Mark E. Jones, PE
Structural Engineering and Design

August 26, 2024

Ref: Site Observations and Analysis
248 Tutor Rd.
Fuquay-Varina, NC
Permit No: SFD2404-0078
Project No: 24-034

A2.1
FIRST FLOOR PLAN

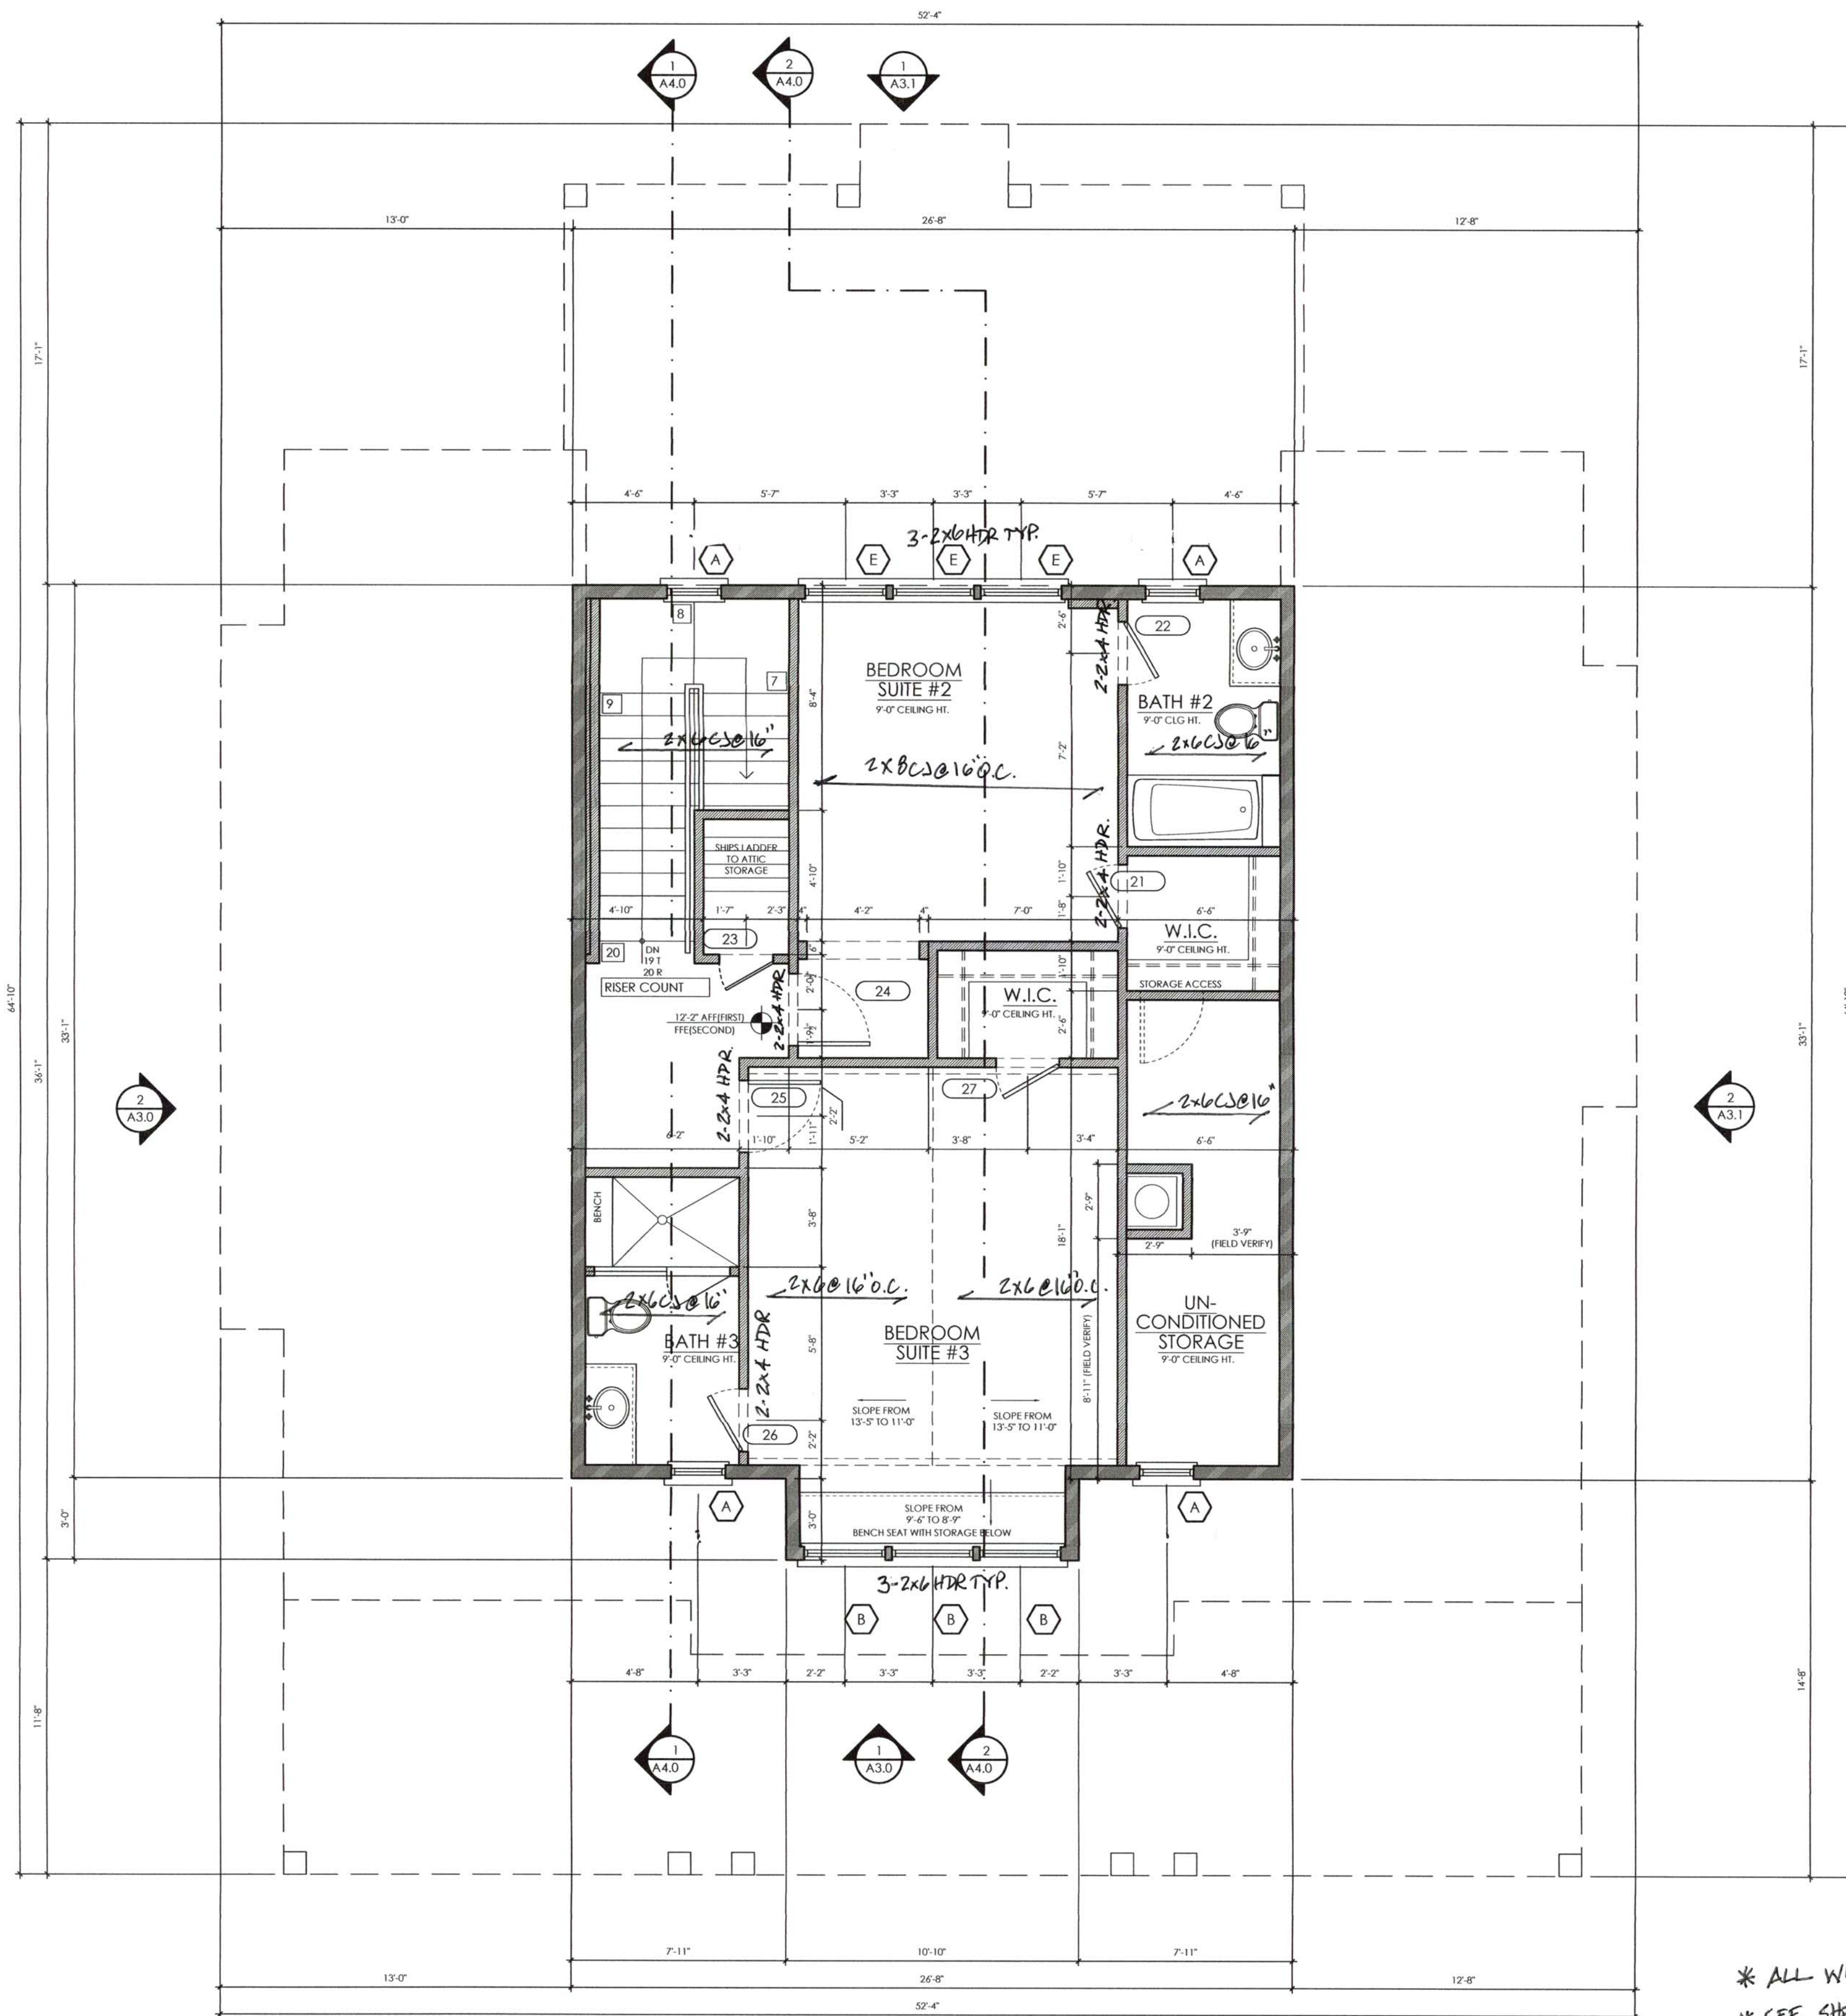
1. 3-2x8 header at master door.
2. 2-lvl hips right side of front porch.
3. Where tile shower was swapped...Should there be any bearing headers due to plan showing headers...

8. Engineer to clarify stud pocket notification at kitchen windows.
9. Engineer to verify floor system and framing at Screened Porch, converted to Sunroom.
10. The builder has framed a single 18' wide garage door in lieu of the plan specified pair of single 9' doors.

1. The builder has installed a 3-2x8 header above the pocket door into the master closet in lieu of the plan specified 3-2x10 header. The installed header will adequately support all imposed design loads. No action is required.
2. A single 9 1/4" LVL hip will support all imposed design loads at the right front corner of the front porch roof. No action is required.
3. The builder has rearranged the master bath such that the water closet, linen closet and coat closet (foyer) are omitted, as well as the load bearing headers as specified on the plans. The 14" I-joists now clear span from the wall at the foyer/bath to the exterior wall. The existing construction will adequately support all imposed design loads. No action is required.
8. The "SP" indicator between the windows above the kitchen sink indicates a minimum of a "1 stud" pocket between the windows.

9. The plan indicated Screen Porch has been converted to a Sunroom with a crawl space foundation. The foundation consists of 2x10 floor joists spaced at 12" on center. Also, all headers above the windows are 3-2x10s. The existing construction is adequate to support all imposed design loads. No repairs or modifications are required.
10. The 18' wide garage door has a 3-14" LVL header spanning the opening. The existing construction will adequately support the imposed design loads. No action is required.
